**SSD 9349 – GLENDELL CONTINUED OPERATIONS PROJECT OPEN CUT COAL MINE –  
666 HEBDEN ROAD SINGLETON**

TfNSW has reviewed the referred Environmental Impact Statement (EIS) prepared by Umwelt and dated November 2019, and the Traffic and Transport Impact Assessment prepared by Puliypang and dated 27 September 2019. The following comments are provided to assist the consent authority in making a determination:

Figure 7: Proposed MIA and Conceptual Hebden Road Realignment (Northern Section)

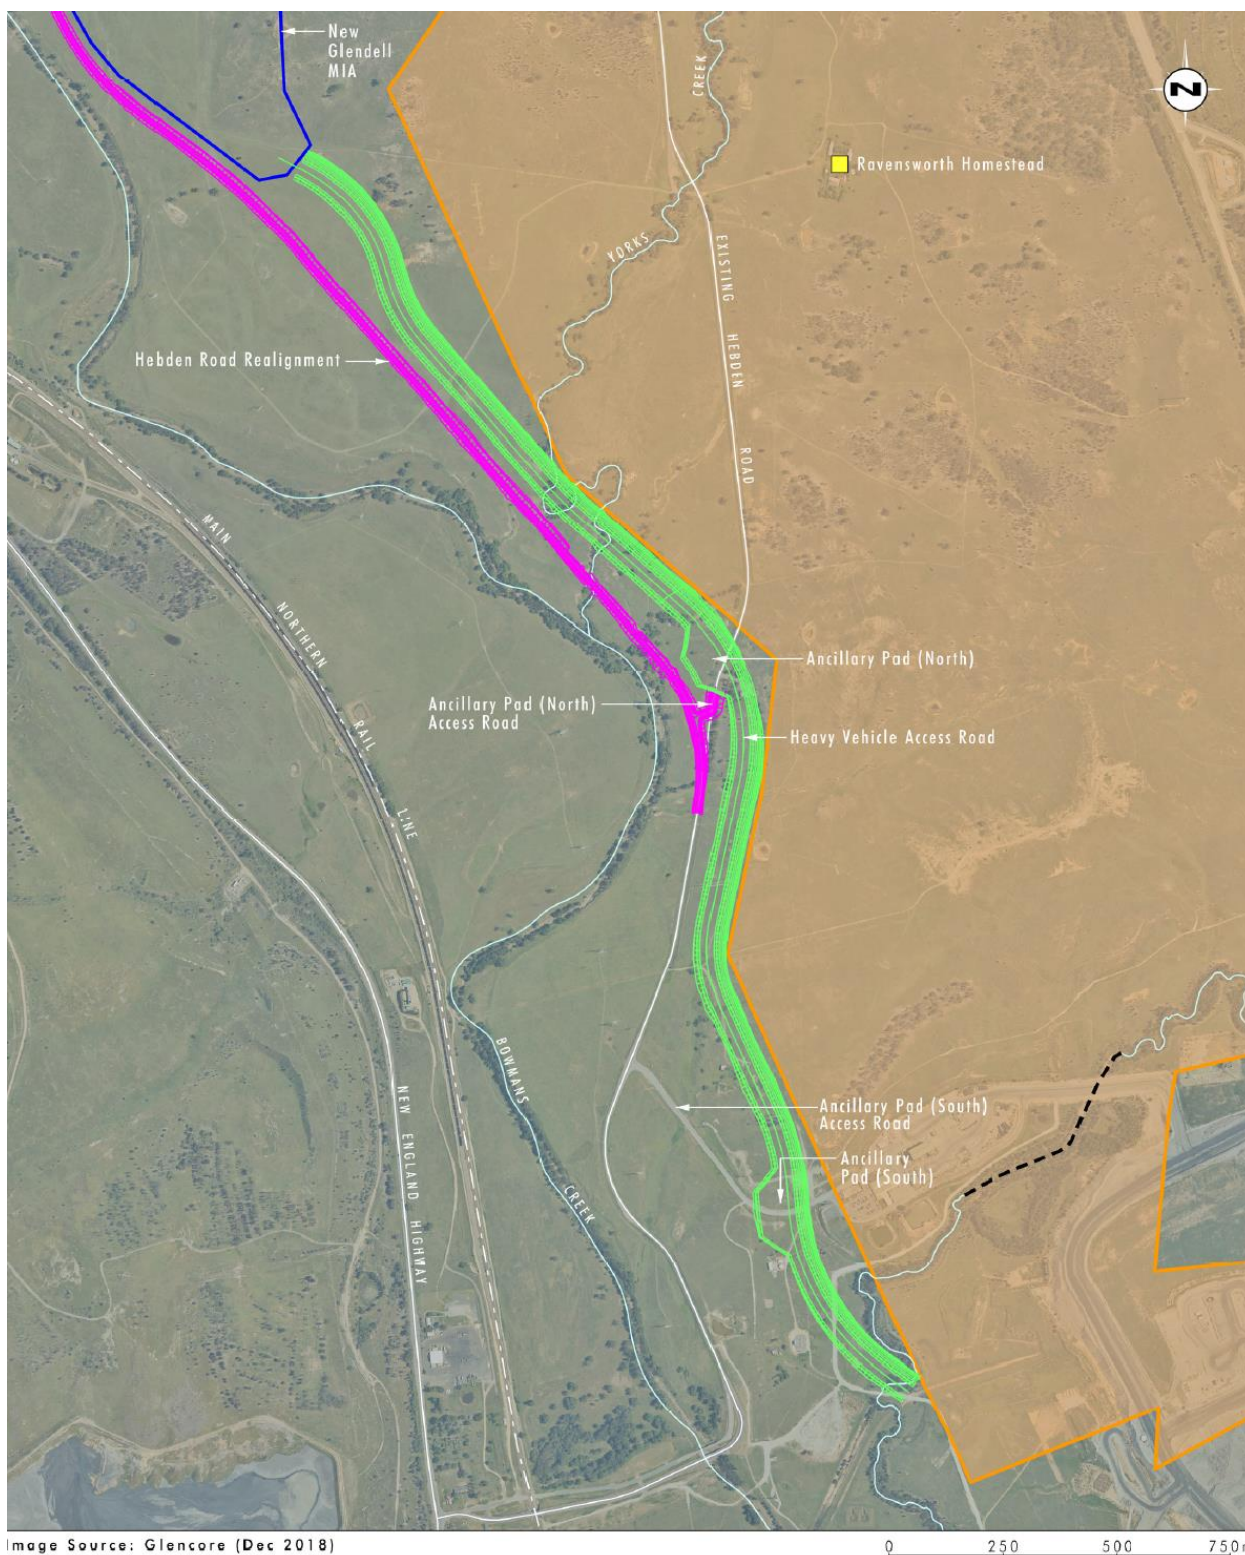
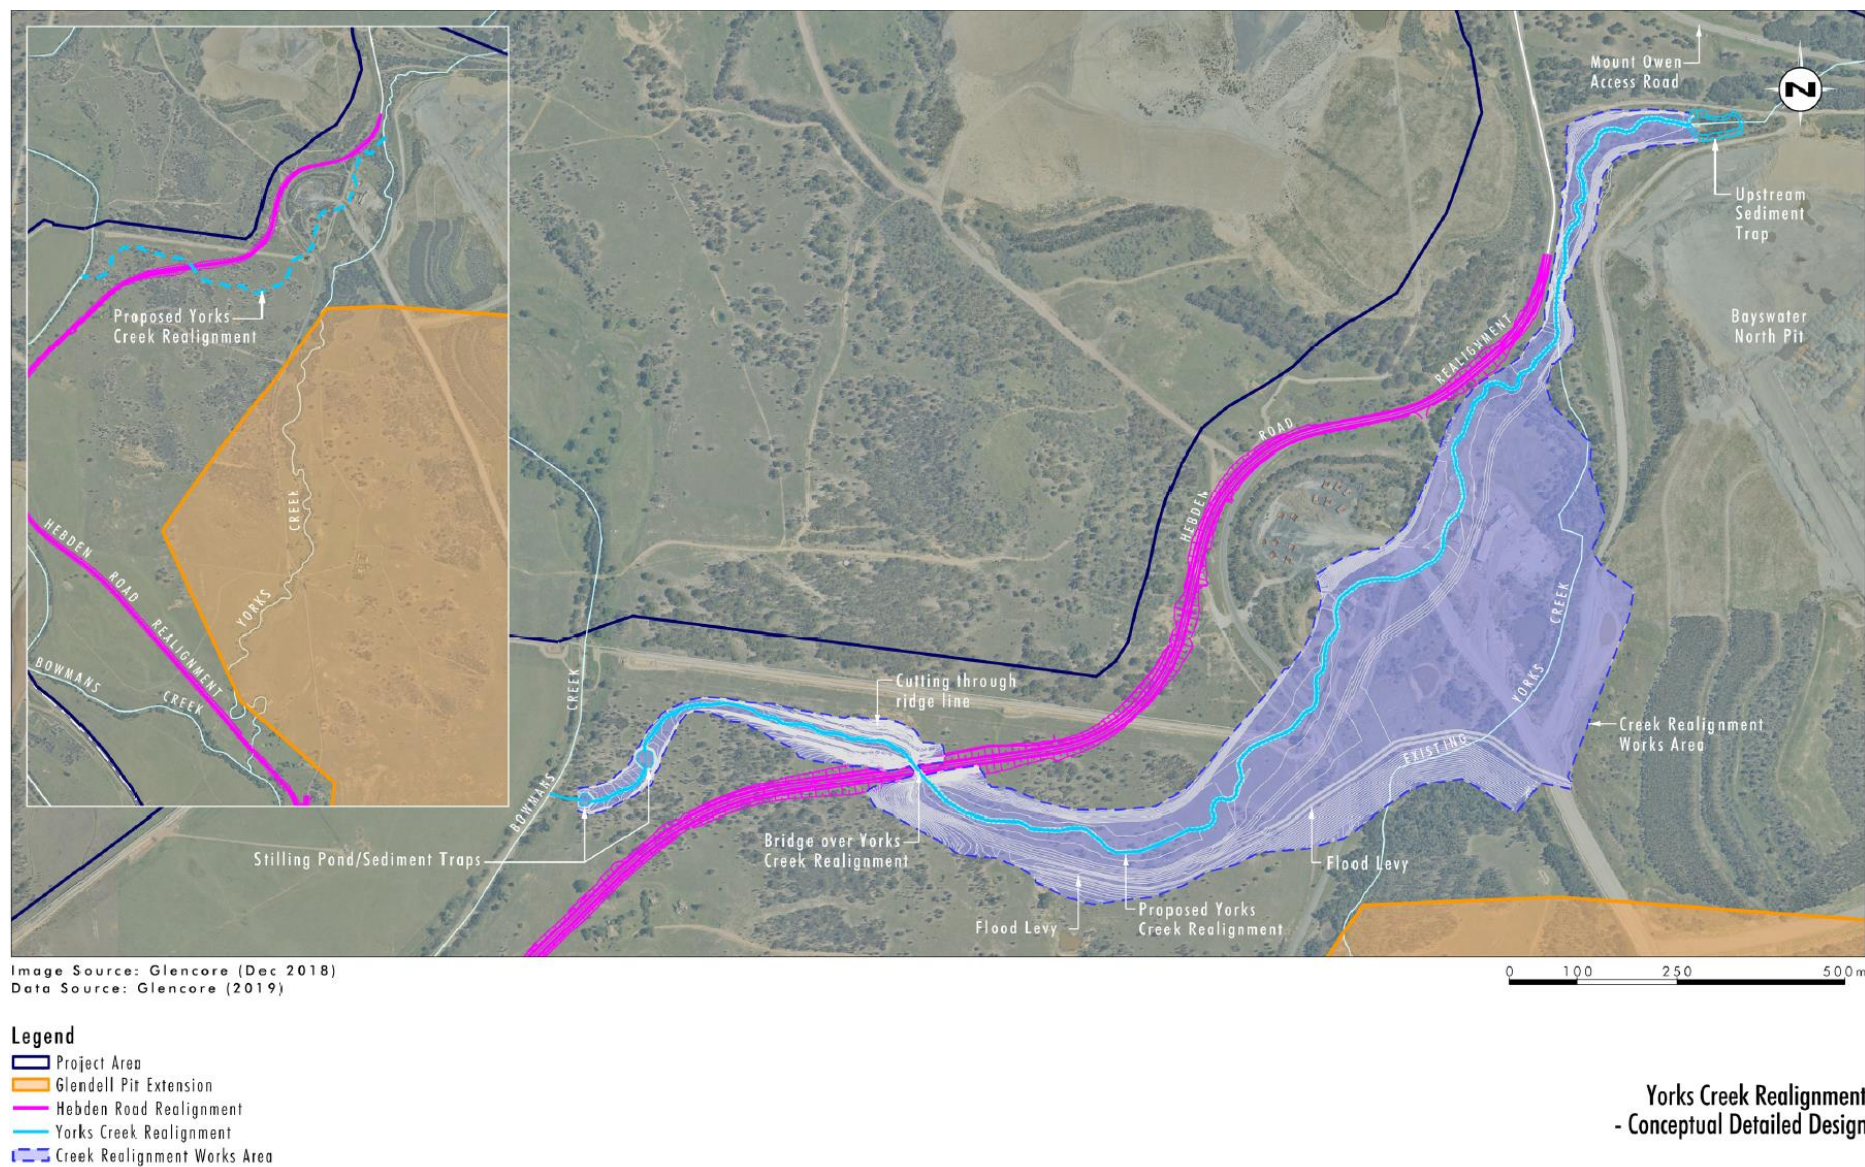
- The proponent shall ensure that the realigned section of Hebden Road will be maintained for 25/26m B-Double (current access level).
- The type of heavy vehicles has not been mentioned in the EIS or Transport and Traffic Impact Assessment, so the assumption is that the existing type of heavy vehicles will be used for the continued operations and are included in the assessment and modelling process.
- It is noted that transportation of dangerous goods such as fuel and explosive are not mentioned in the EIS, however, hazardous waste transportation has been considered.
- Clarification is required in regards to the Mount Owen Rail Loop upgrade work. This SSD application mentioned the realignment of the existing loop, however, the Mount Owen Coal Complex Modification 2 mentioned an additional rail line that will connect to the existing rail loop and the Main North Rail Line.
